From: Michael Eastham <Michael.Eastham@arun.gov.uk>
Sent: 15 December 2020 13:51
To: Planning.Responses <Planning.Responses@arun.gov.uk>
Cc: Claire Potts <Claire.Potts@arun.gov.uk>
Subject: FW: A/166/20/DOC - Manor Nursery, High Street, Angmering

Please upload onto Ocella the email below which is a consultation response from the **ADC Drainage Engineers** objecting to Conditions 21 and 22 of discharge of condition application **A/166/20/DOC** relating to Manor Nursery, High Street, Angmering.

Subject: Re: A/166/20/DOC - Manor Nursery, High Street, Angmering

CLIENT	Roffey Homes Ltd		
PROJECT	Manor Nurseries Site Angmering		
TITLE	Proposed Drainage Strategy		
DRAWN	DATE	PROJECT NO.	
T Zajac	Mar 2018	22995	
ENGINEER	CHECKED	DWG. NO.	REV.
S Magowan		102	D
SCALE	1:250 @ A1

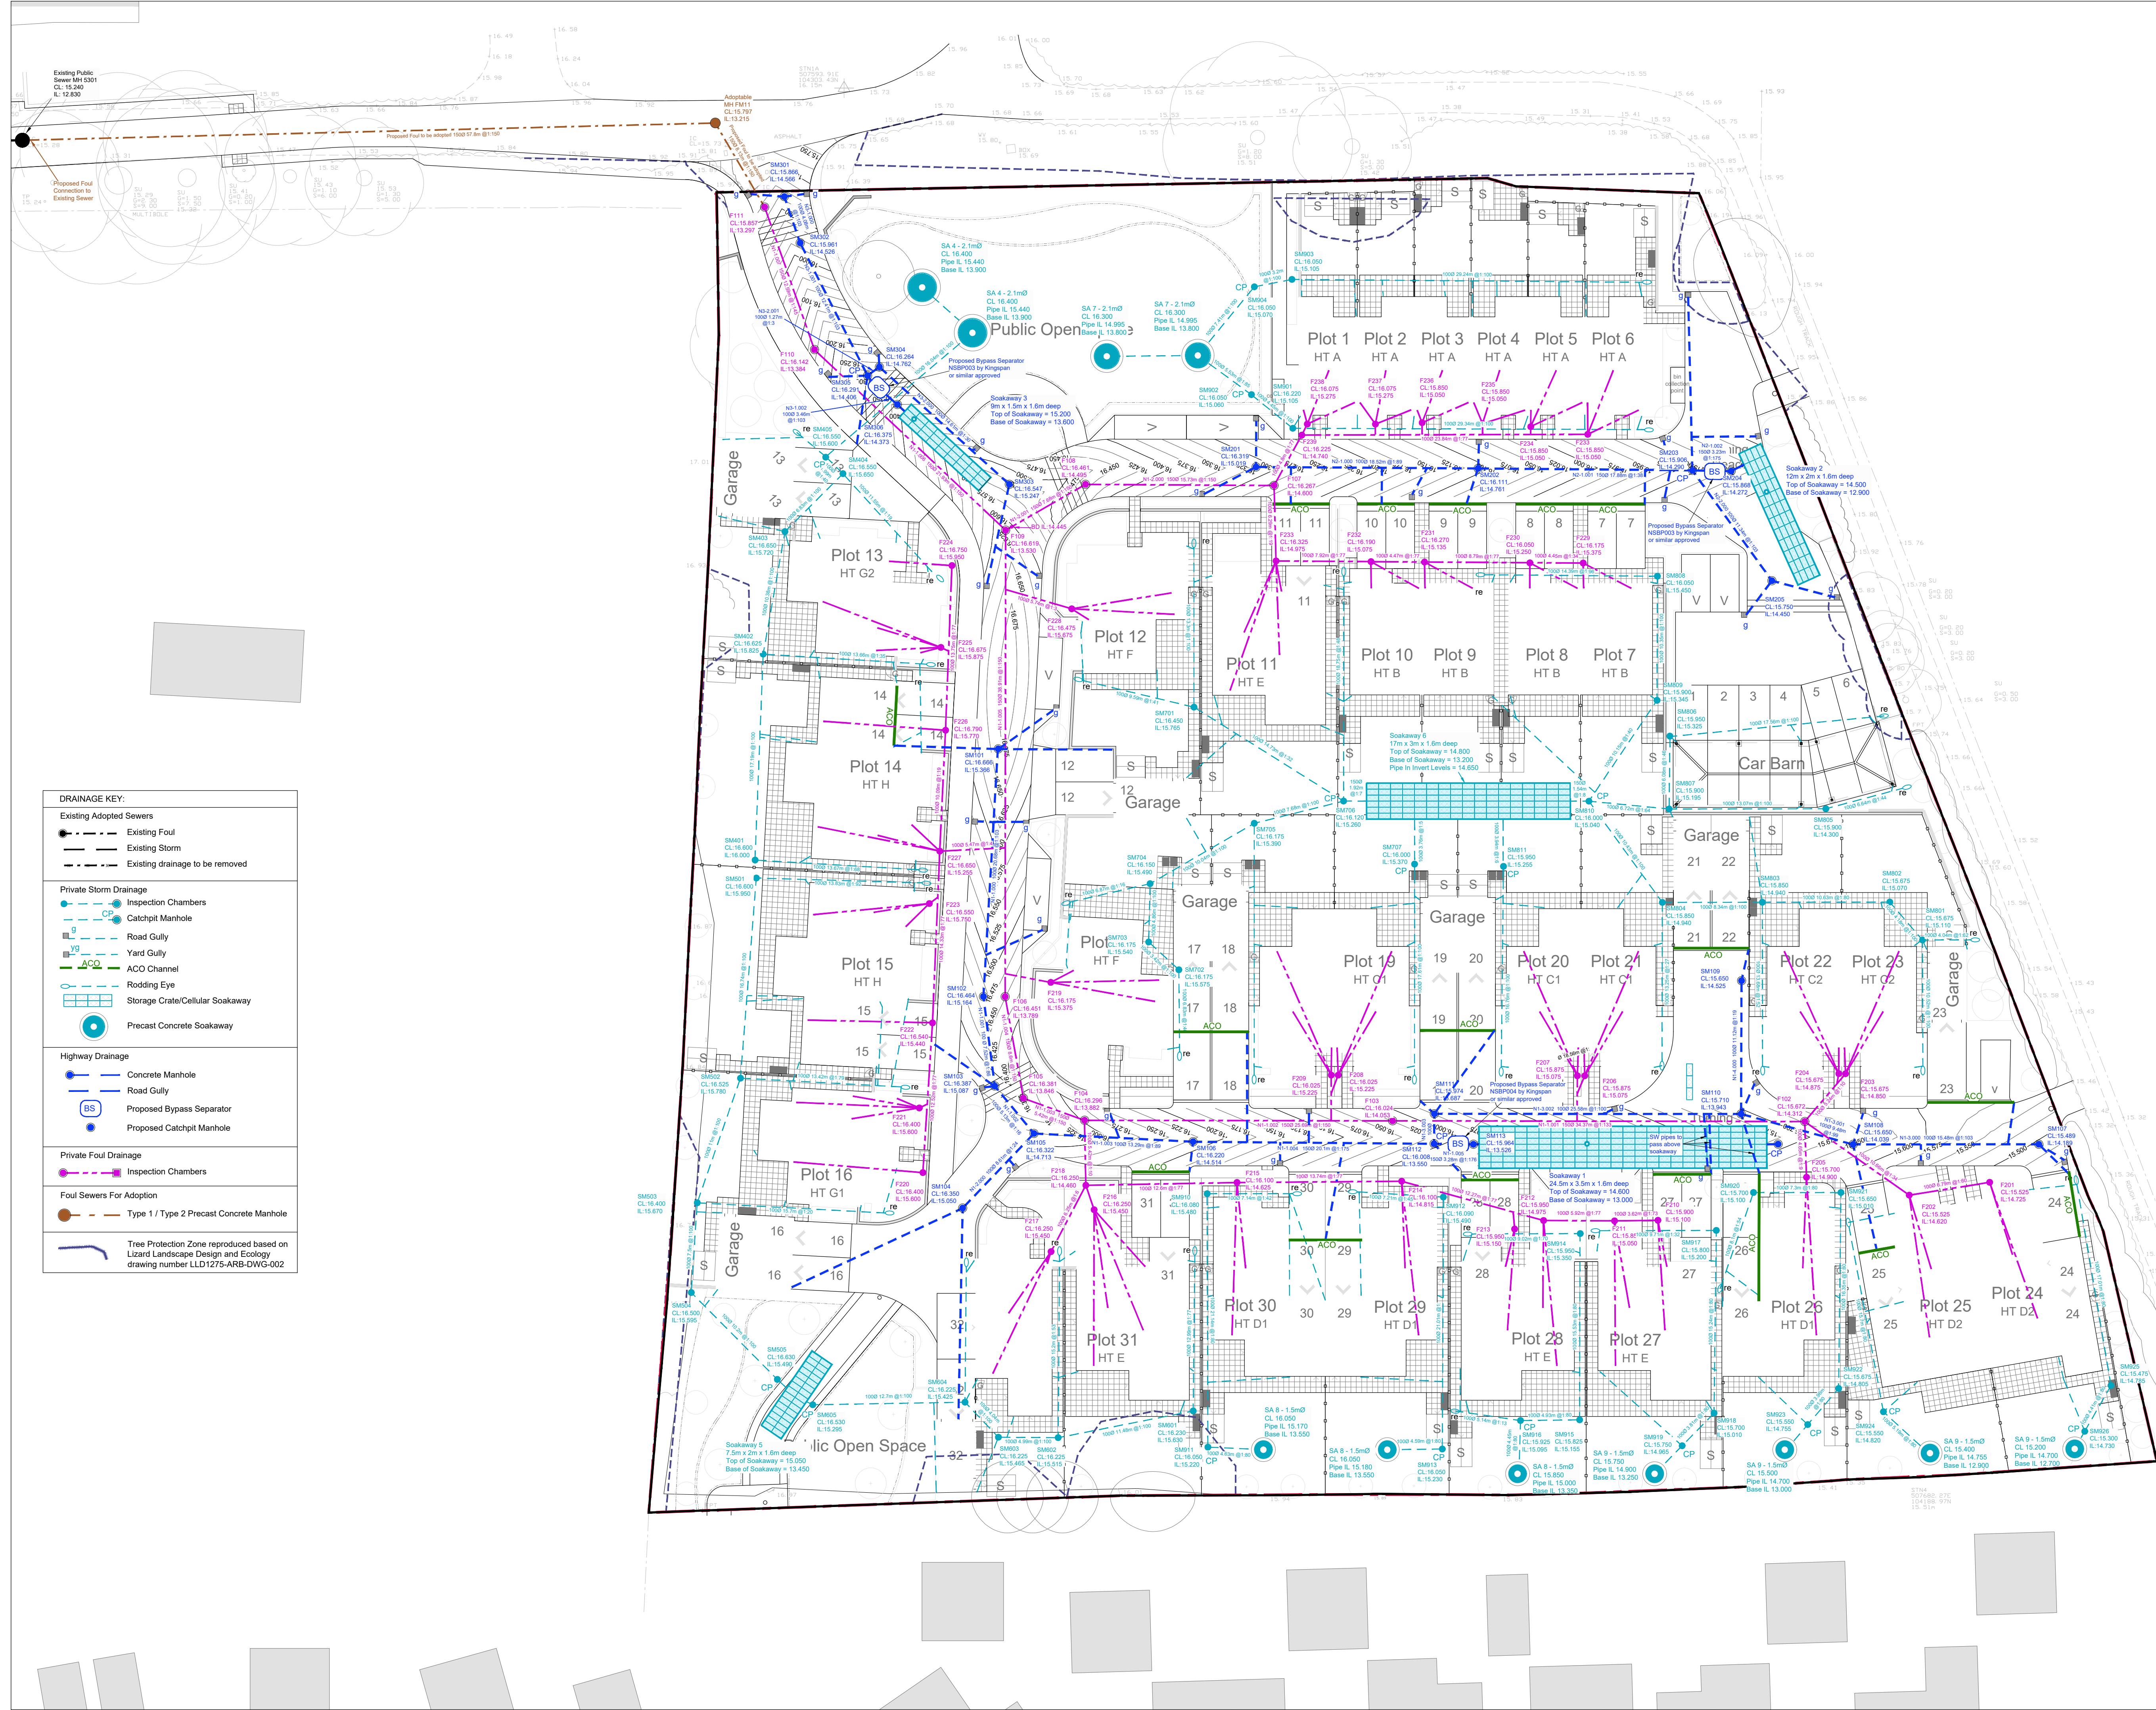
The information submitted regarding **Condition 21** imposed on the outline planning permission A/51/14/OUT: relating to the full details of the proposed surface water drainage scheme is refused as insufficient information has been submitted to ensure the proposed development is satisfactorily drained.

The information submitted regarding **Condition 22** imposed on the outline planning permission A/51/14/OUT: relating to the full details of the maintenance and management of the surface water drainage system is refused as insufficient information has been submitted to ensure the efficient maintenance and ongoing operation of the SuDs system and to ensure the best practice in line with guidance set out in *The SuDs Manual CIRIA publication ref: C753 Chapter 32*.

I would suggest that we cannot recommend refusal of condition 6- this is for two reasons. 1. the condition was not requested by ourselves. 2. The information submitted evidences that the site drains so should not flood the highway. The information submitted does not evidence that it will not pollute groundwater, thus why we would recommend refusal of the application for the discharge of condition 21.
